Manorwood Homes

Lince Lane,
Kirtlington

Project Reference: 2207-015/TN/01A

Technical Note

Drawing Title:  
**PROPOSED SITE PLAN**

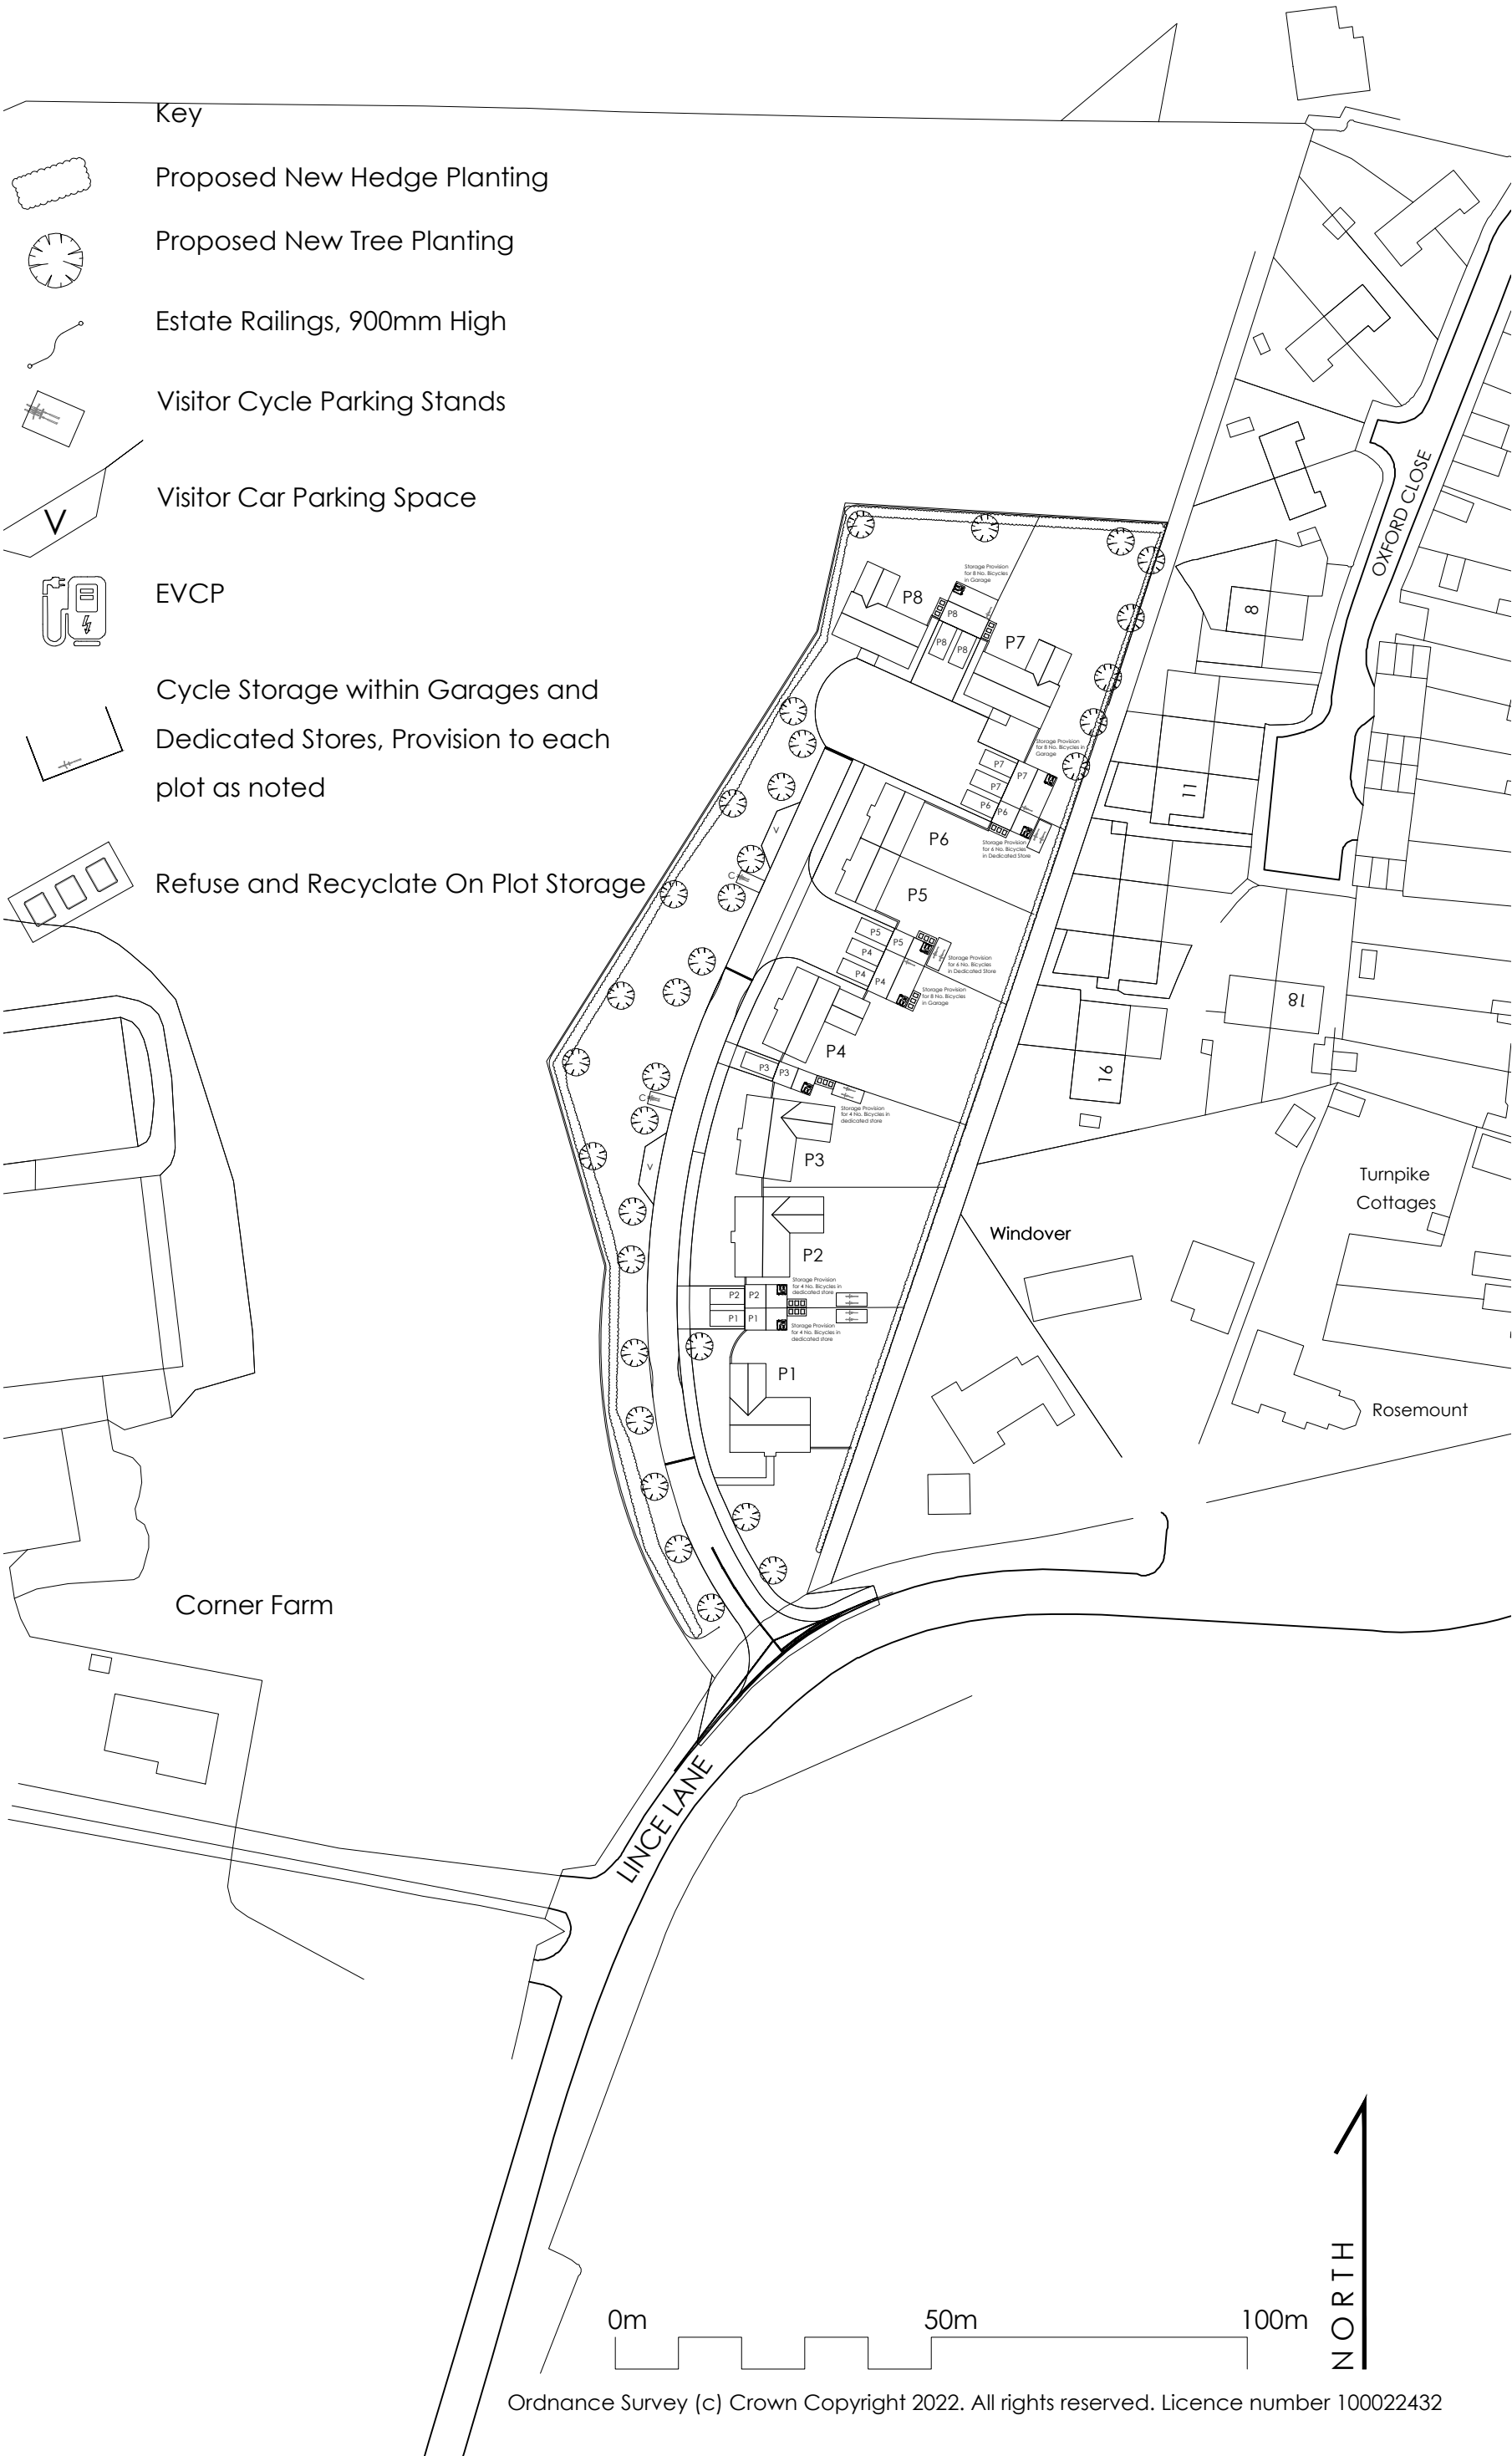
“When assessing Table 4.1 within the Transport Statement, it contains both discrepancies between it and the site plan, but also has properties that do not conform to the New OCC Vehicular and Cycle Parking Standards:

Plot 4: *4/5 bed properties can have up to 3 spaces in rural localities, 1 space is not sufficient for a property of this size.*

Plot 5: *Shown on site plan as having 1 space, but table shows it having 2, due to its size, it should have a minimum of 2.*

Plot 6: *Due to its size, it should have 2 parking spaces.*

Plot 7: *Showing to have 1 in table 4.1, 2 on the site plan. 1 space is not sufficient for a property of this size.*

Plot 8: *Showing to have 1 in table 4.1, 2 on the site plan. 1 space is not sufficient for a property of this size.*

The visitor parking provision exceeds the maximum standards set by OCC, there should be a provision of 1 visitor space per 5 dwellings, in this case it should be rounded up to 2.”

“OCC’s new Vehicular and Cycle Parking Standards state that in order for cycle parking provision to comply with guidance set out within LTN 1/20, cycle parking must be provided at 1 space per bedroom. Table 4.1 does not reflect this.”

2.15 The site layout has been reviewed in light of the standards and the revised layout is shown in the attached SJ Design drawing 1001.102 H. The parking provision for each unit is summarised below:

2.19 It is acknowledged that since the planning application was submitted that OCCs have adopted new parking standards guidance with regards to cycle parking. As such, following the above advice, the layout has been amended as shown in the attached SJ Design drawing 1001.102 H. The parking provision for each unit is summarised below:

TITLE:
**On-Site -
Swept Path Analysis of a
Refuse Vehicle**

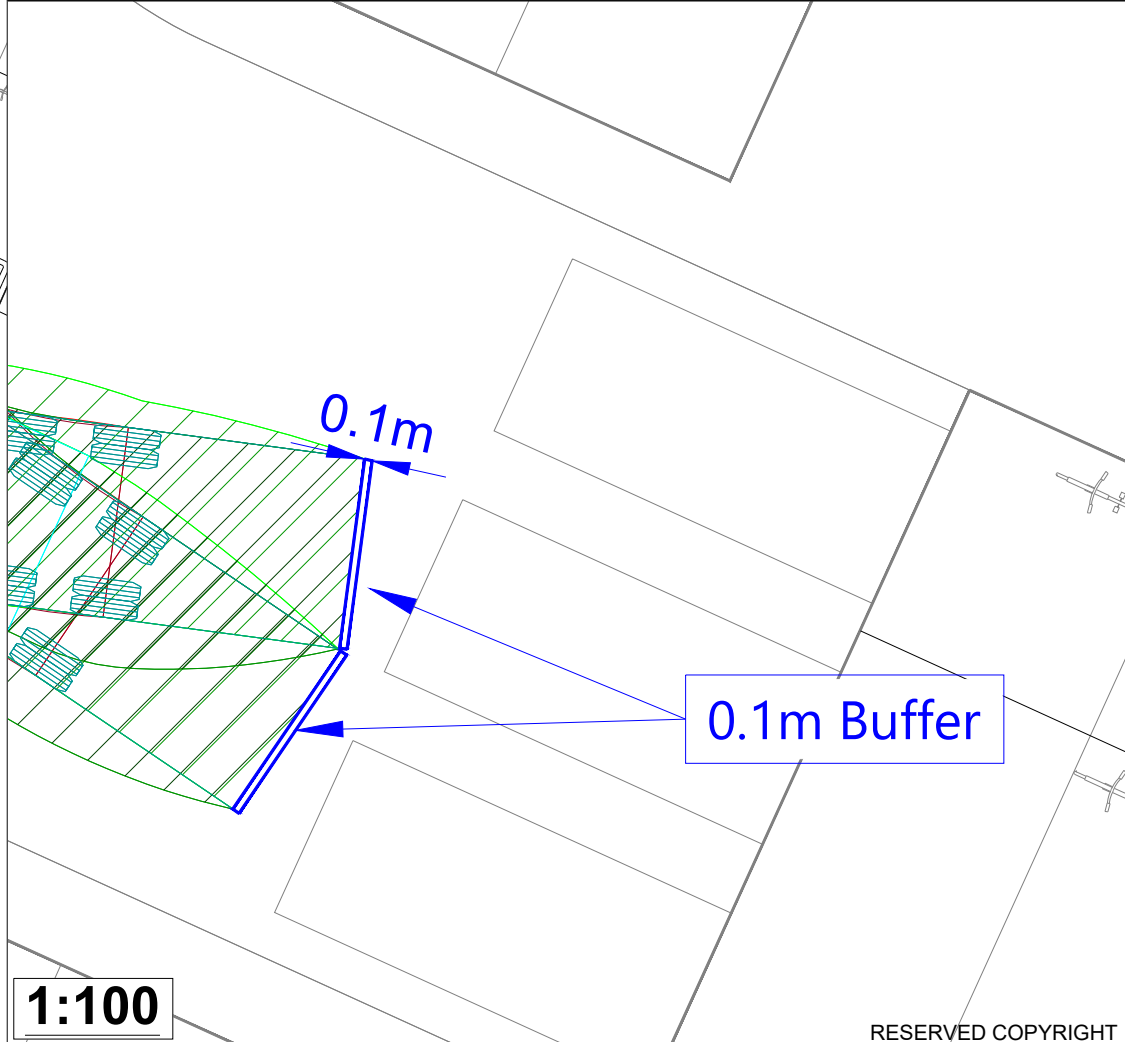
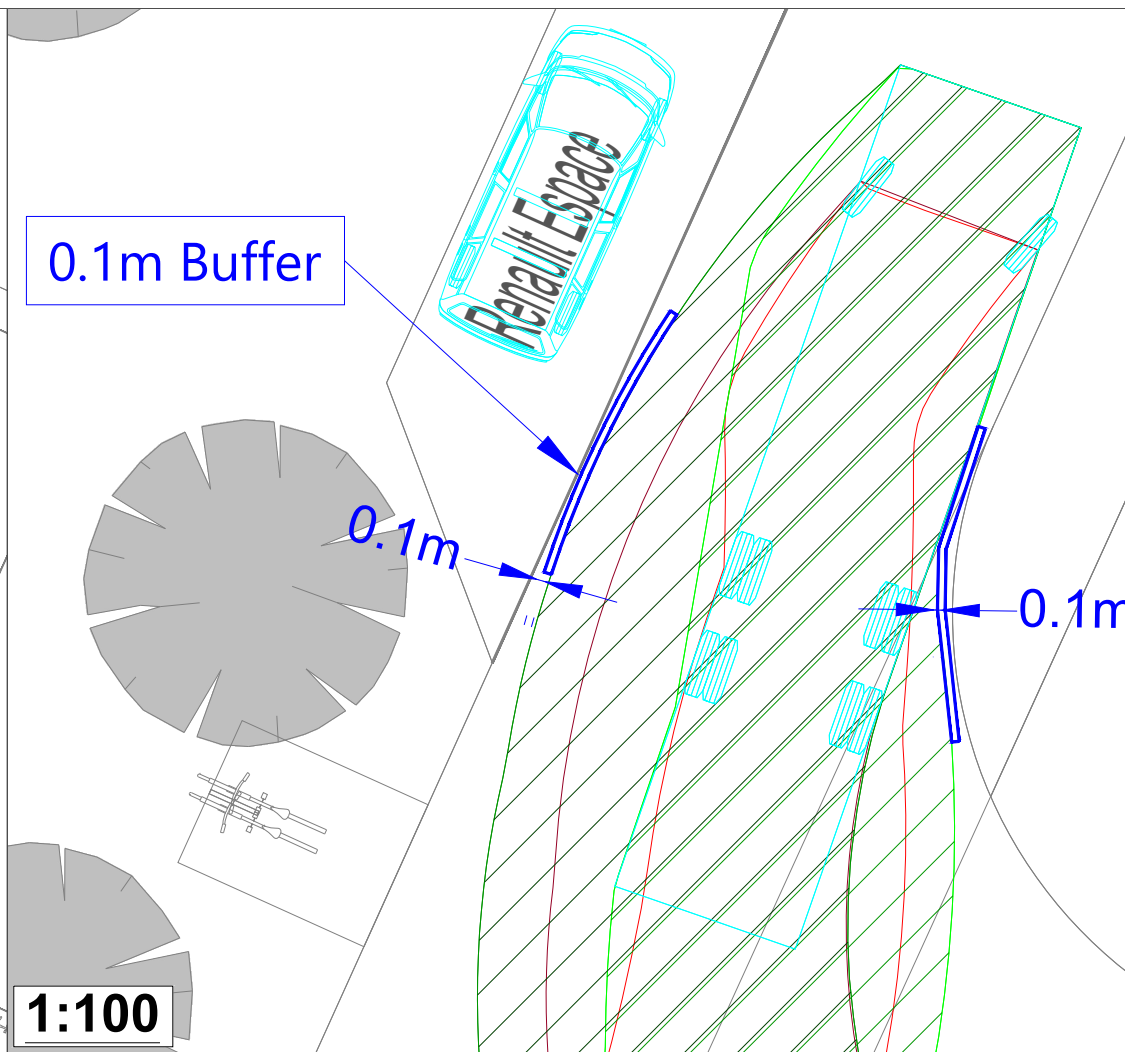
“Given the positioning of the access to this site, it is not going to be possible for refuse vehicles to stop on the A4095. Therefore a swept path analysis for a 11.6m refuse vehicle should be carried out, to prove that it can manoeuvre around the site safely. The vehicle must not overhang any of the footways and should also be tracked passing a parked car.”

- 2.28 Notwithstanding that the refuse vehicle used within the Transport Statement is consistent with CDCs guidance, new swept paths for a larger refuse vehicle have been undertaken. The vehicle tracking software does not have a 11.6m refuse vehicle, the closest being a 11.5m. TPA drawing 22-7-015 SP07A shows the 11.5m refuse vehicle, with a 0.1m ‘buffer’ turning within the site, with no overhang of parking spaces or footways.
